Ribble Valley Borough Council
By email

Your ref 3/2025/0652
Our ref DC/25/2452
Date 28-OCT-25

Location: Hall Barns Farm Knowles Brow Hurst Green BB7 9PT
Proposal: Proposed extension to existing approved agricultural building.

Drawing Title
 EXISTING SITE PLAN

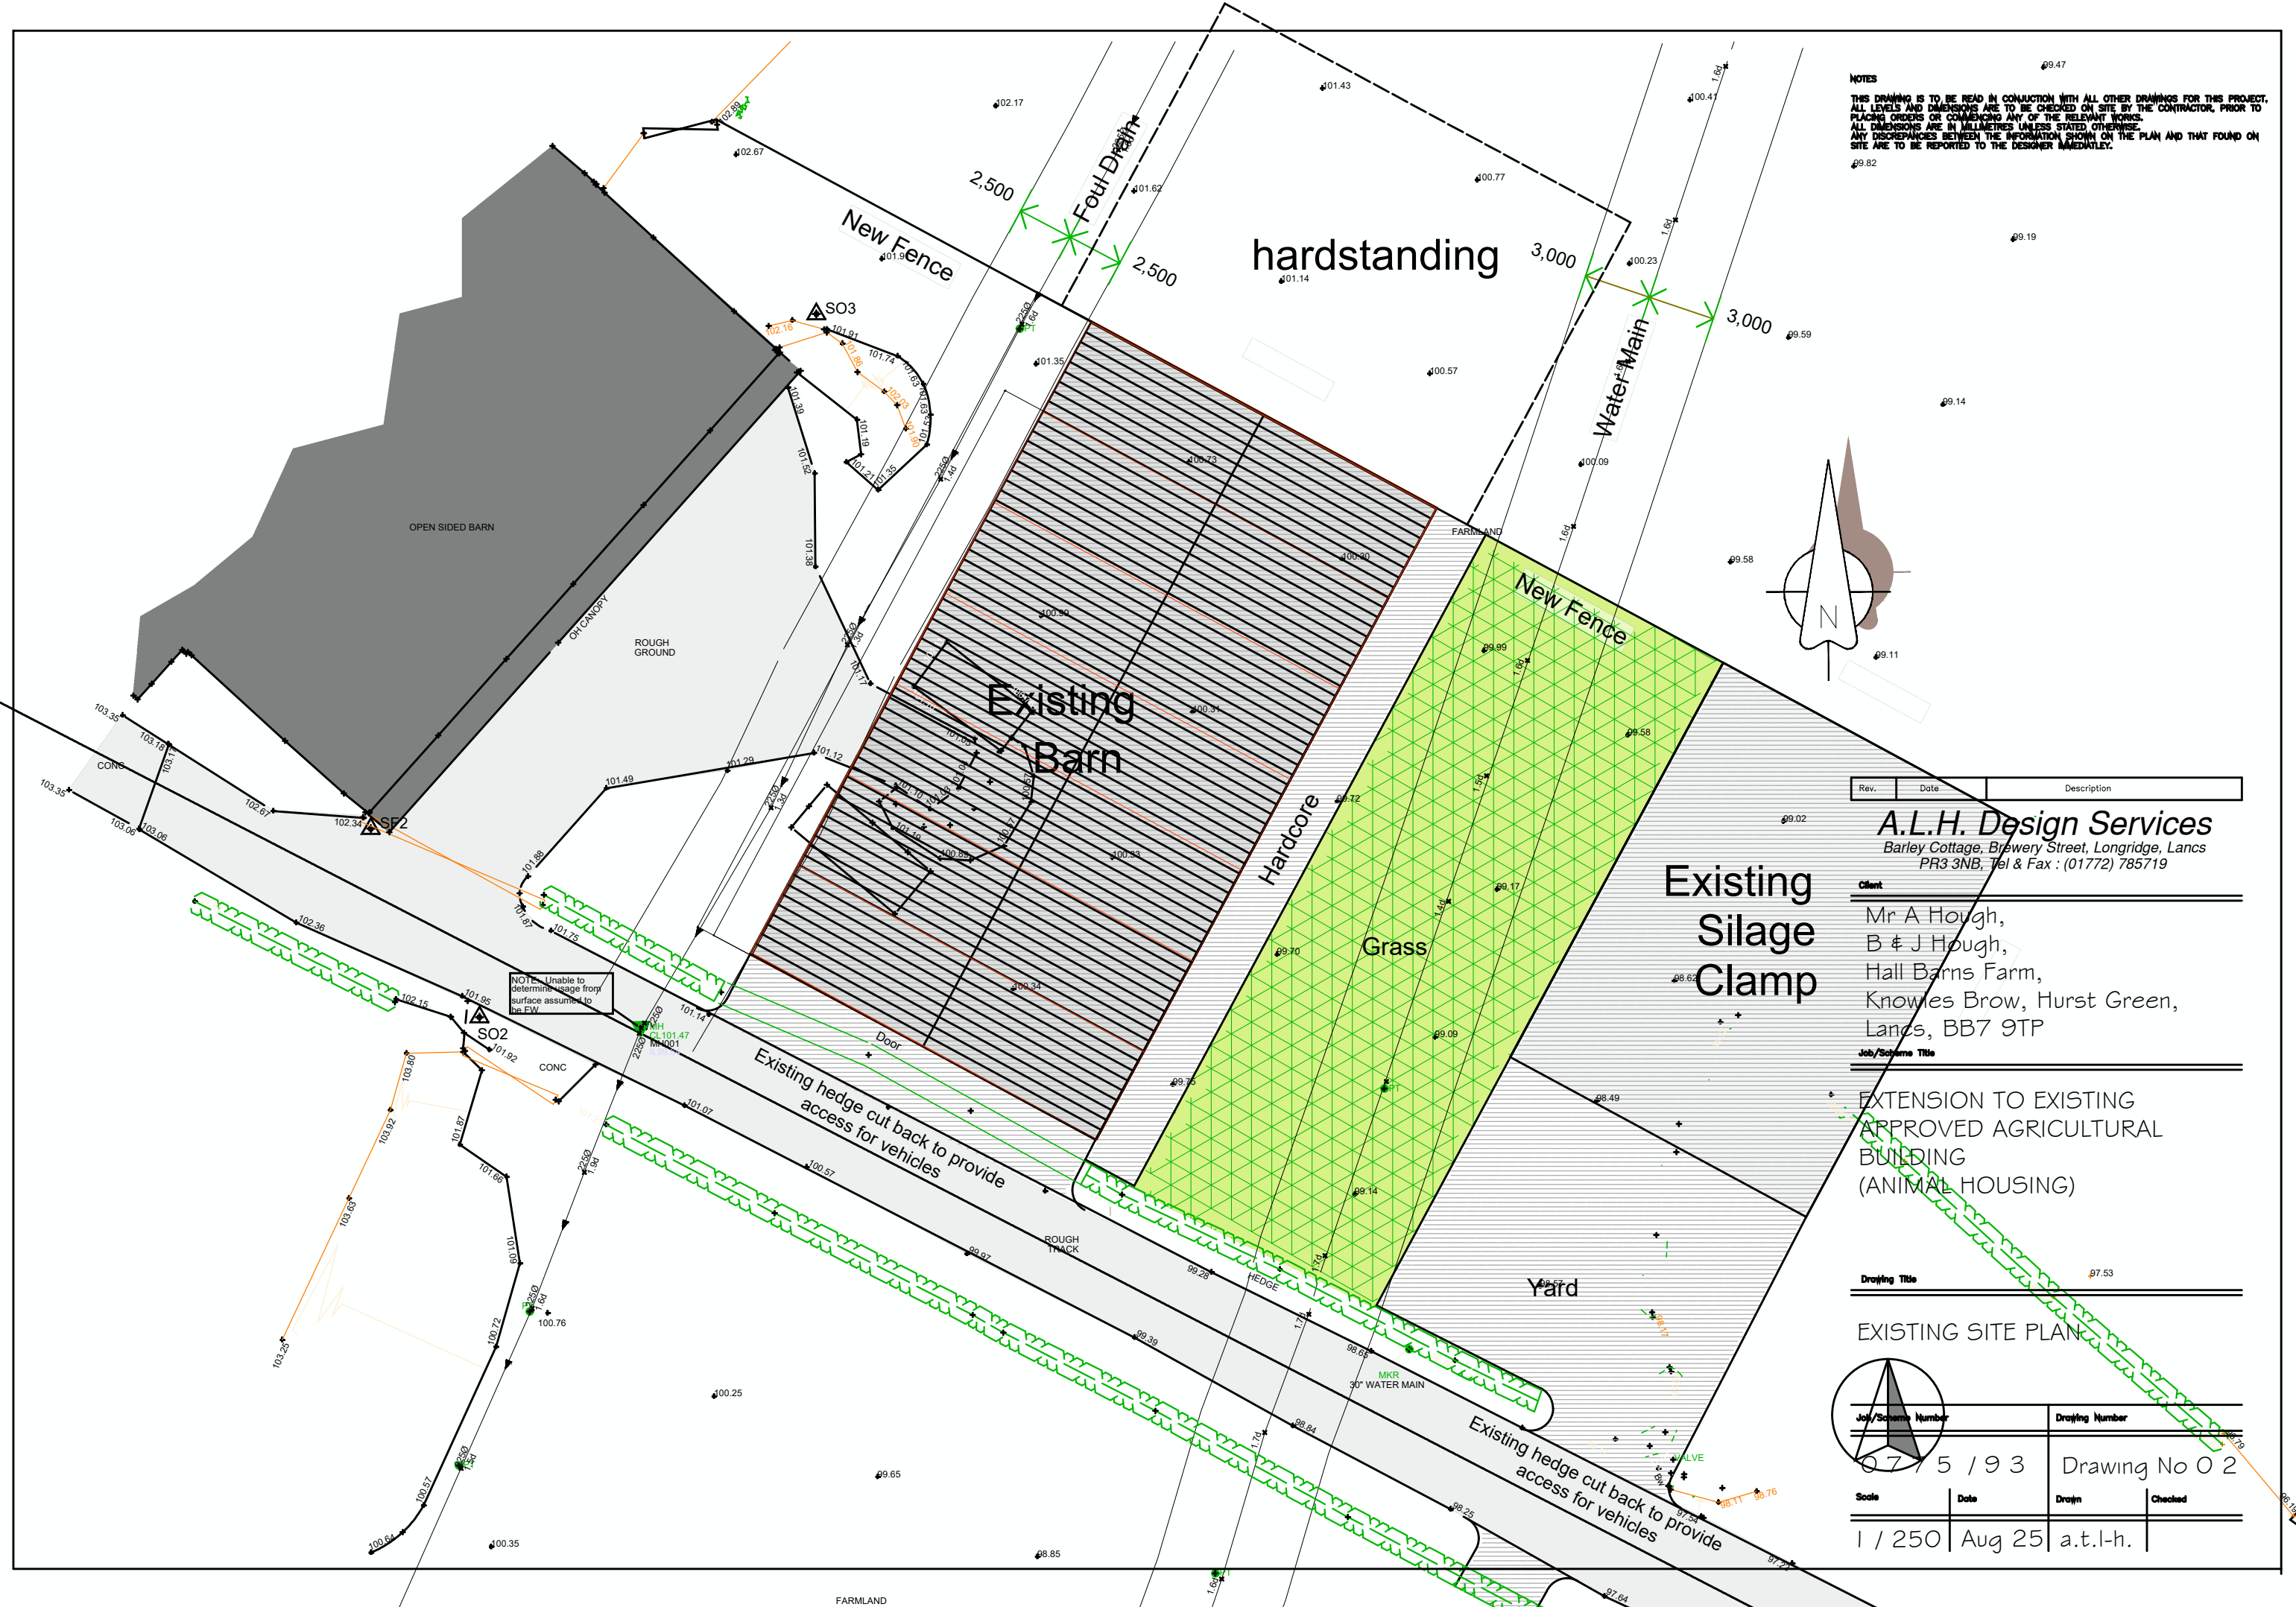
As the submission has identified, development is proposed close to, or potentially over, a United Utilities Water Main on east of the site and the applicant must provide clarity on the **EXACT** location of the asset to ensure it will not be directly built over or within the dedicated easement.

The submission has not yet fully traced the full length of the asset within the red line boundary according to our records, and the proposed development is potentially within the easement of the water main in question. It is important to understand that **we will not permit development over or in the easement** so agreements on the exact location must be agreed to ensure the extension can be delivered.

Drawing Title
 PROPOSED SKETCH PLANS
 (GROUND FLOOR)

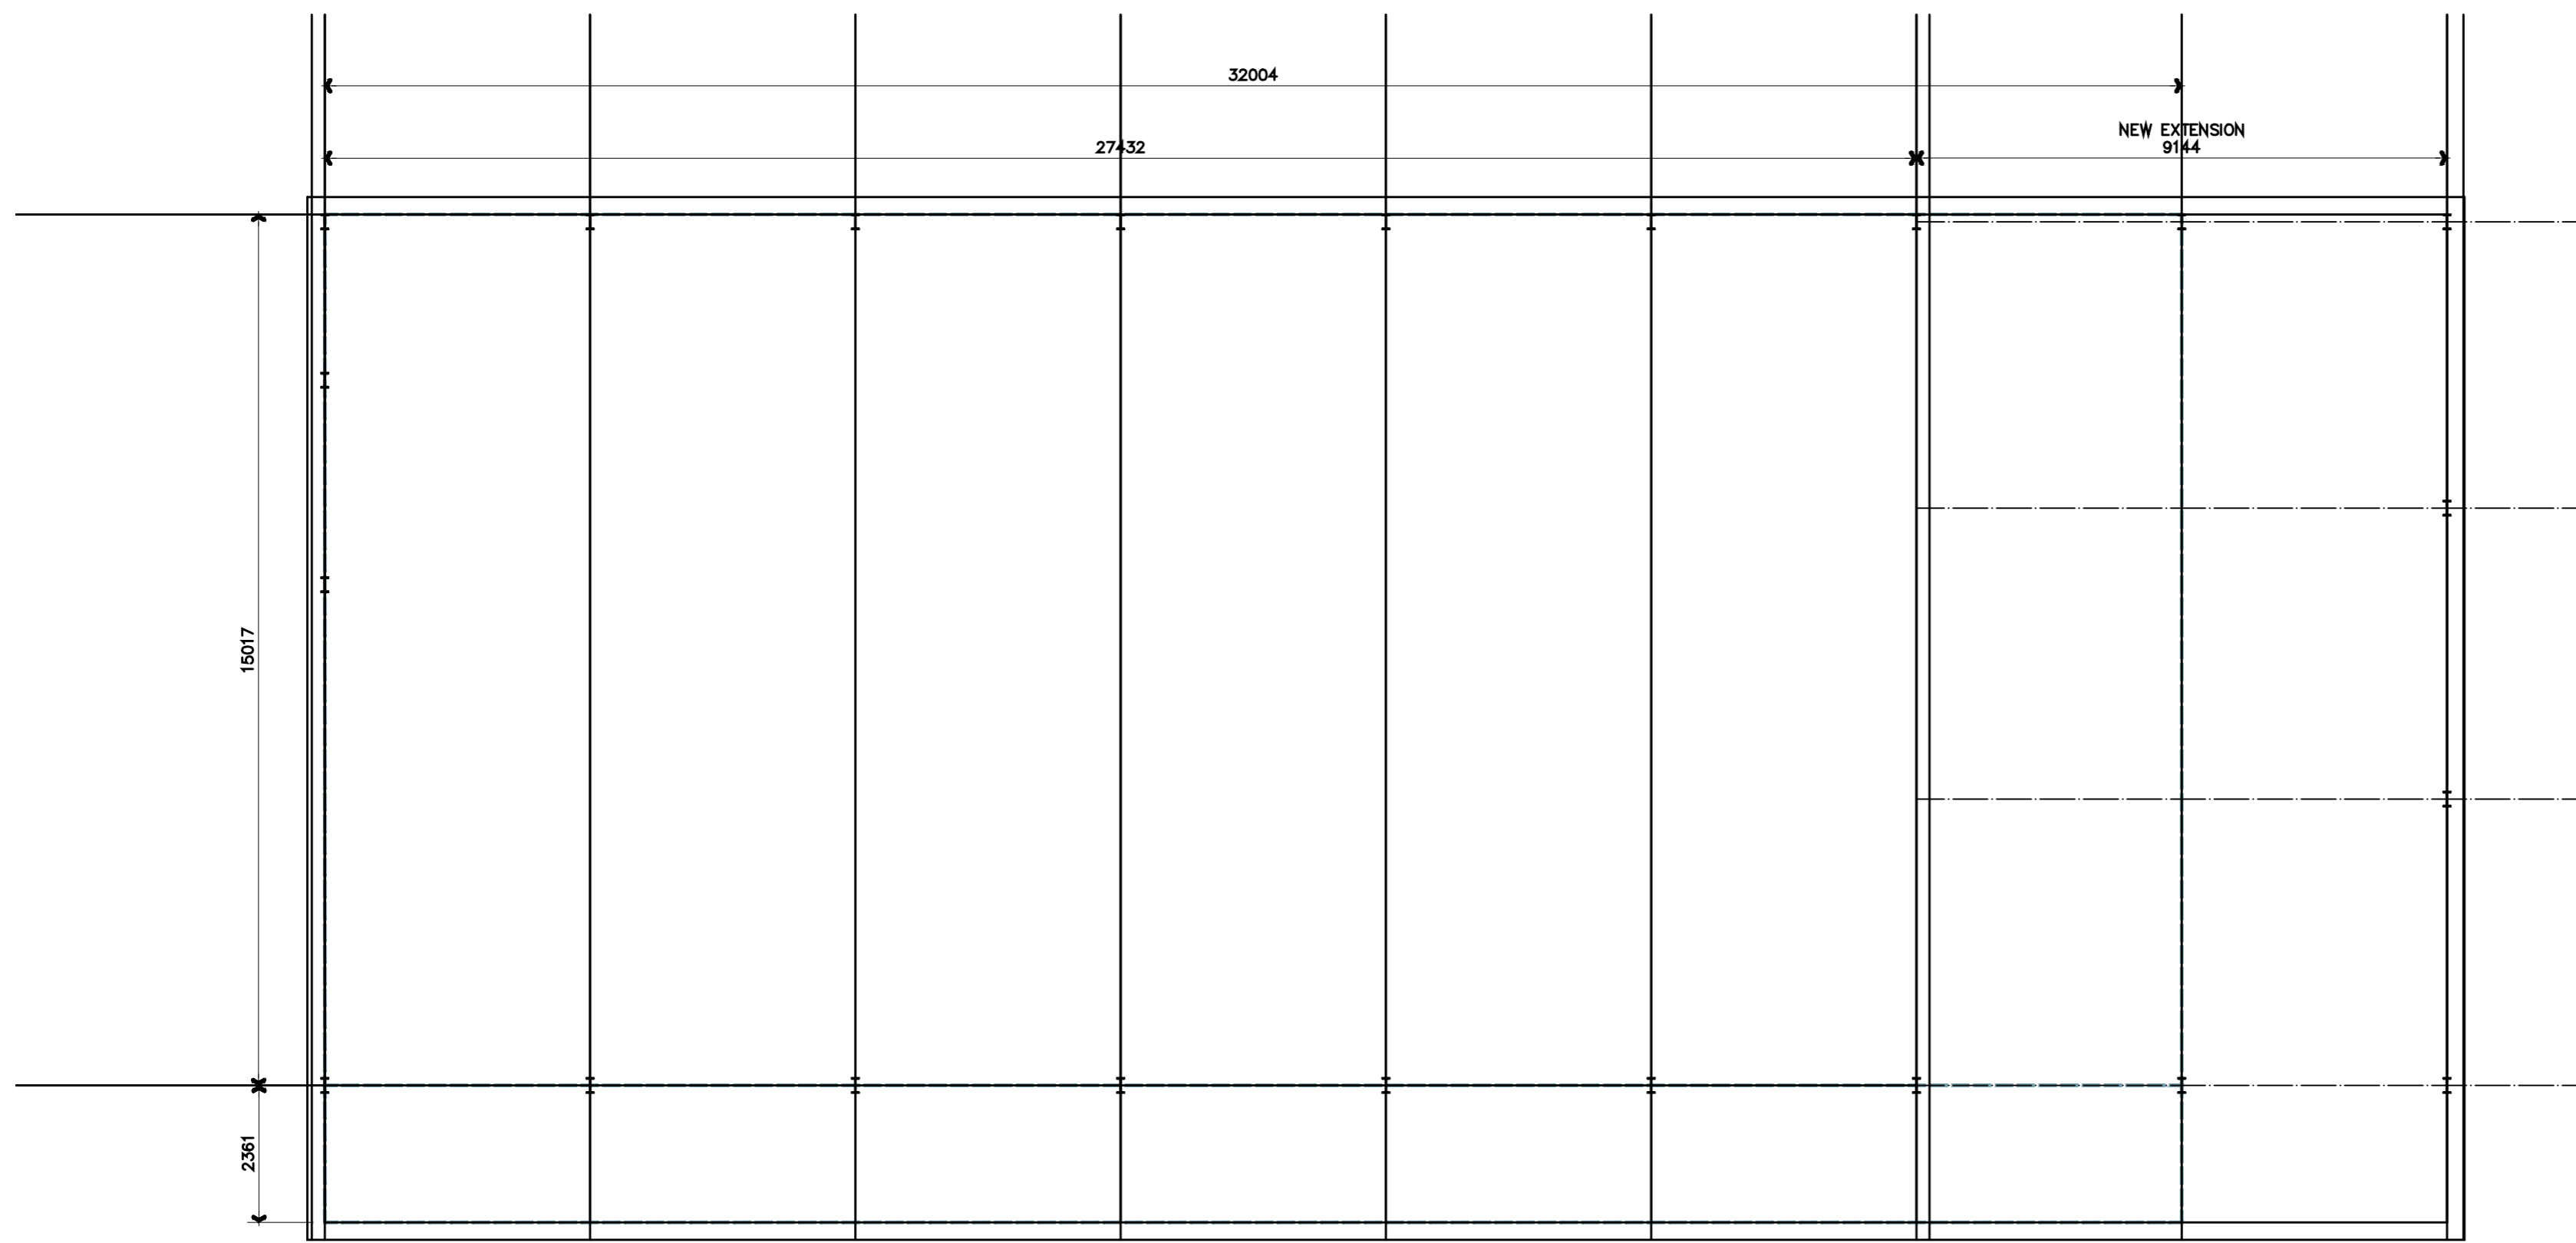
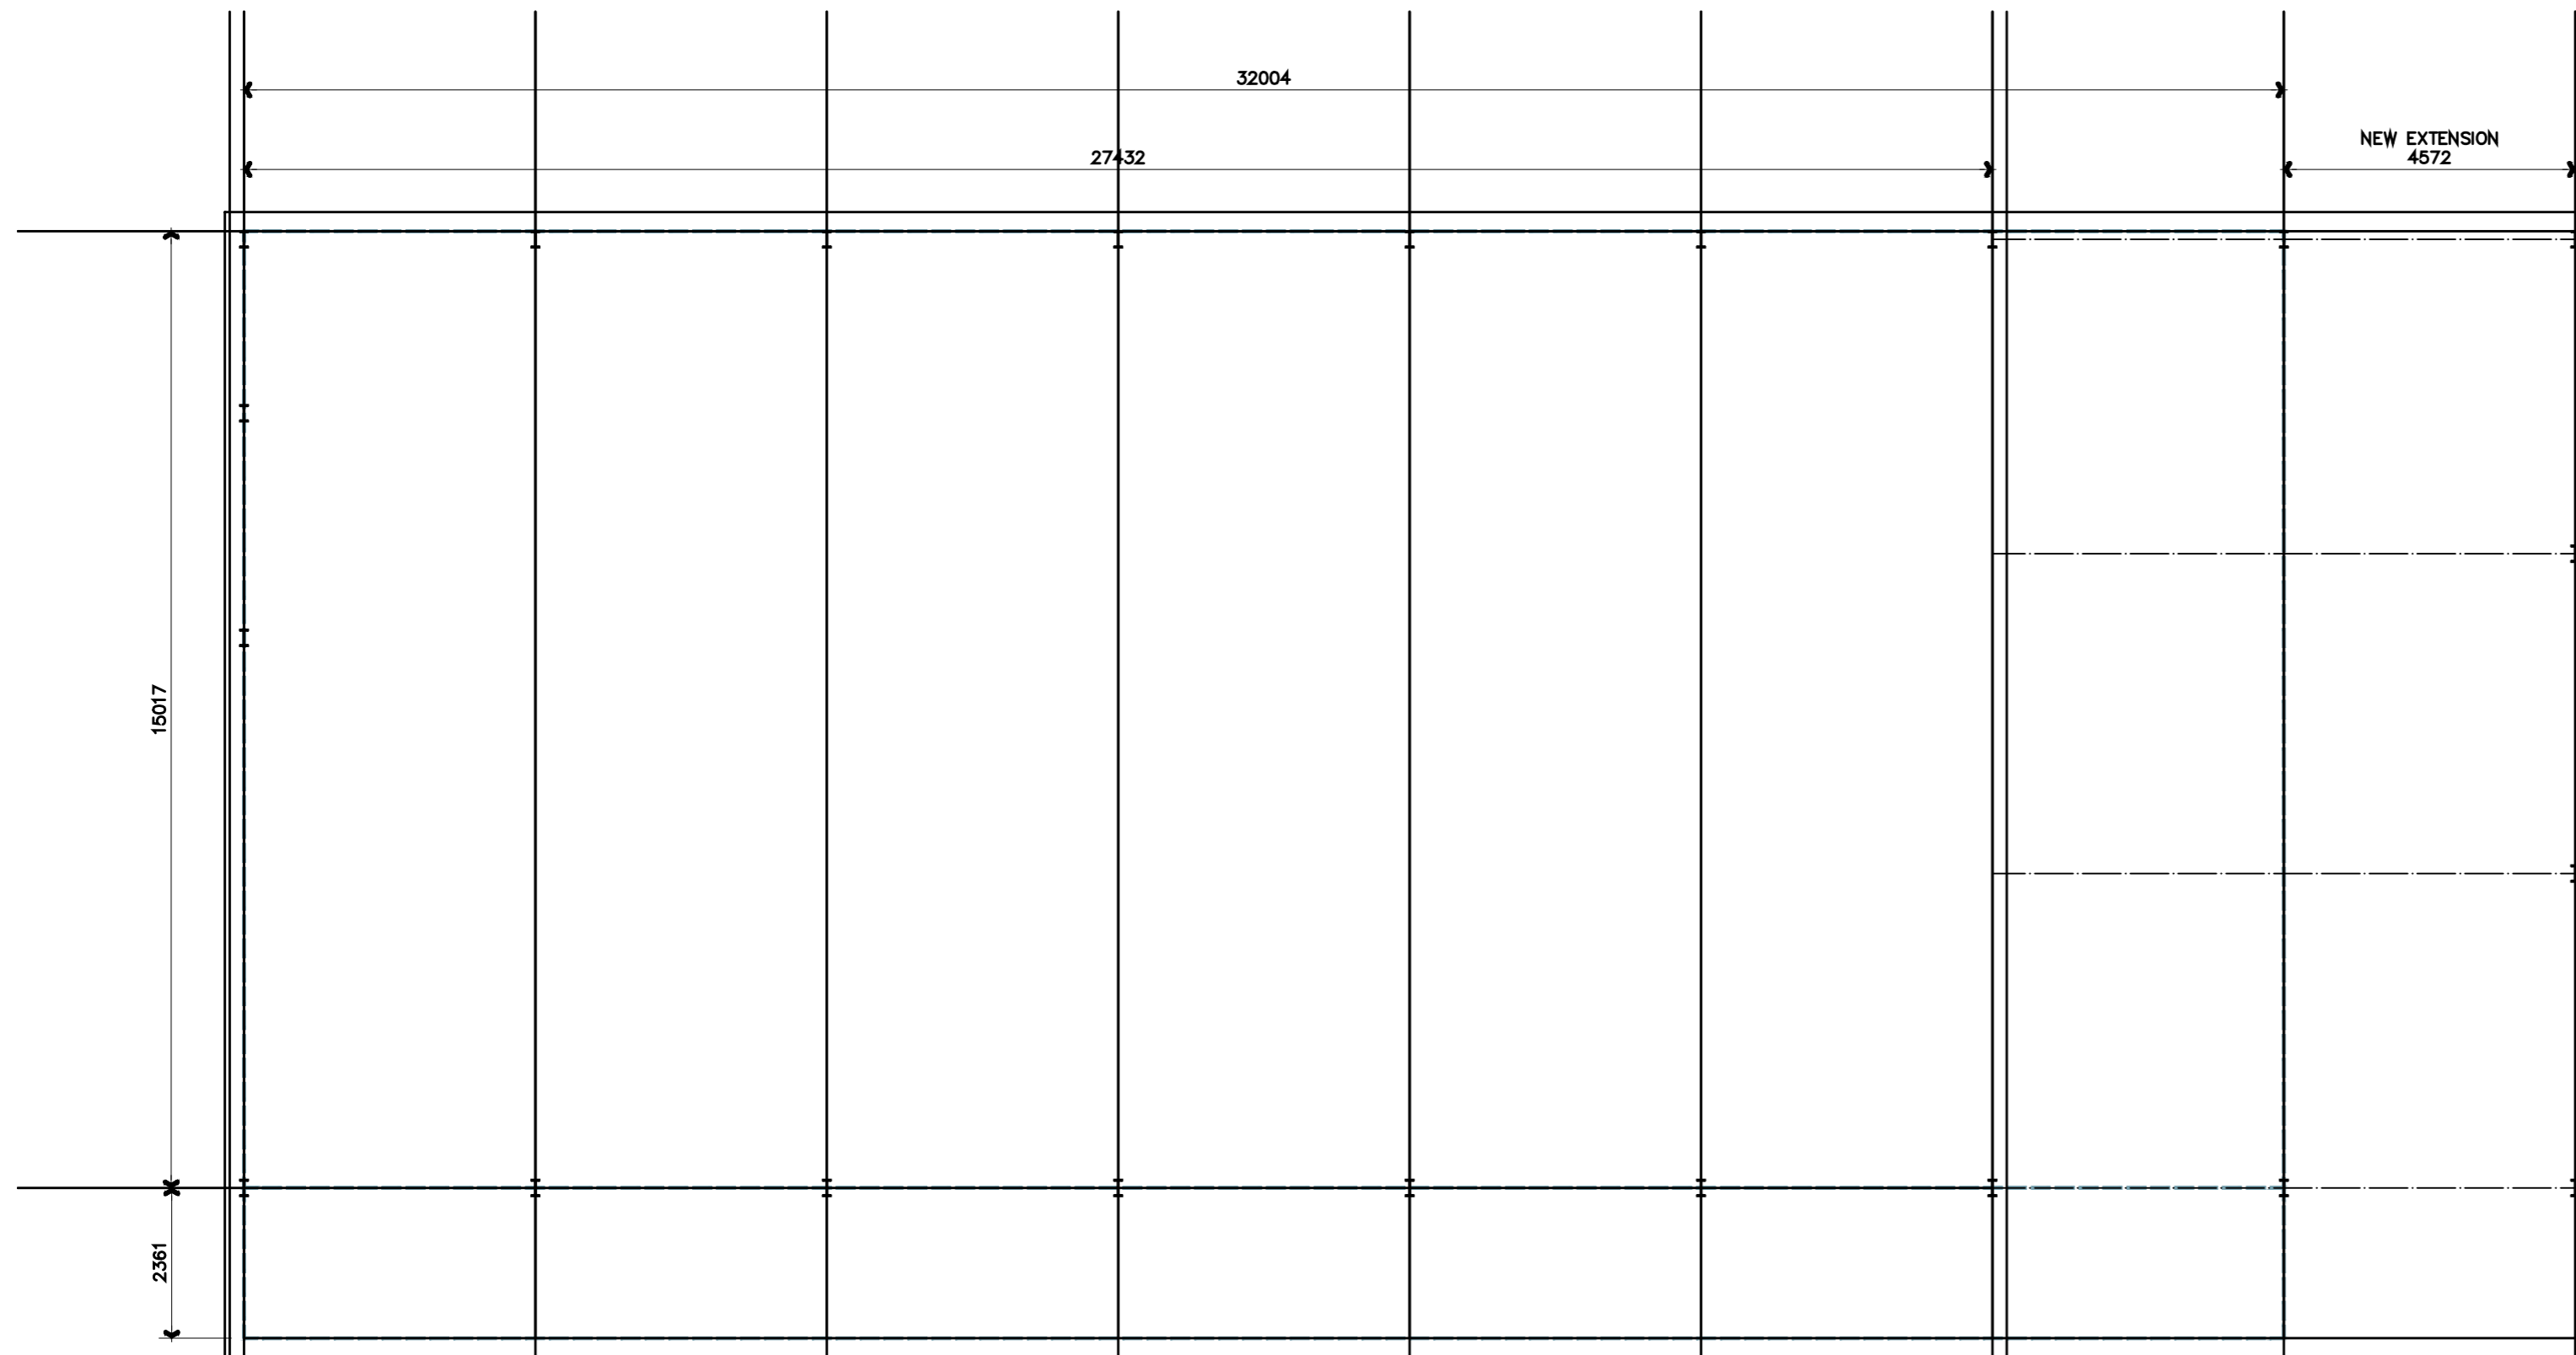
Applicant must be aware of obligation of separate legal easement, **UU ref f 2296**. Consistent with the above, the applicant must avoid building over the pipe or within its easement so agreements on the location of the pipeline are strongly advised.

A public sewer crosses the site and we will not permit building over it. We require an access strip for maintenance or replacement and this access must not be compromised in any way. The minimum distances that might be acceptable to United Utilities are detailed within Part H of the Building Regulations however, we recommend the applicant determines the precise location, size, depth and condition of the pipeline as this is likely to influence the required stand-off distance from any structure.

Based on the information currently available, it is unclear whether sufficient distance is provided between proposed development features and our wastewater asset(s). We recommend the applicant contacts our Developer Services team to ensure existing wastewater assets, along with
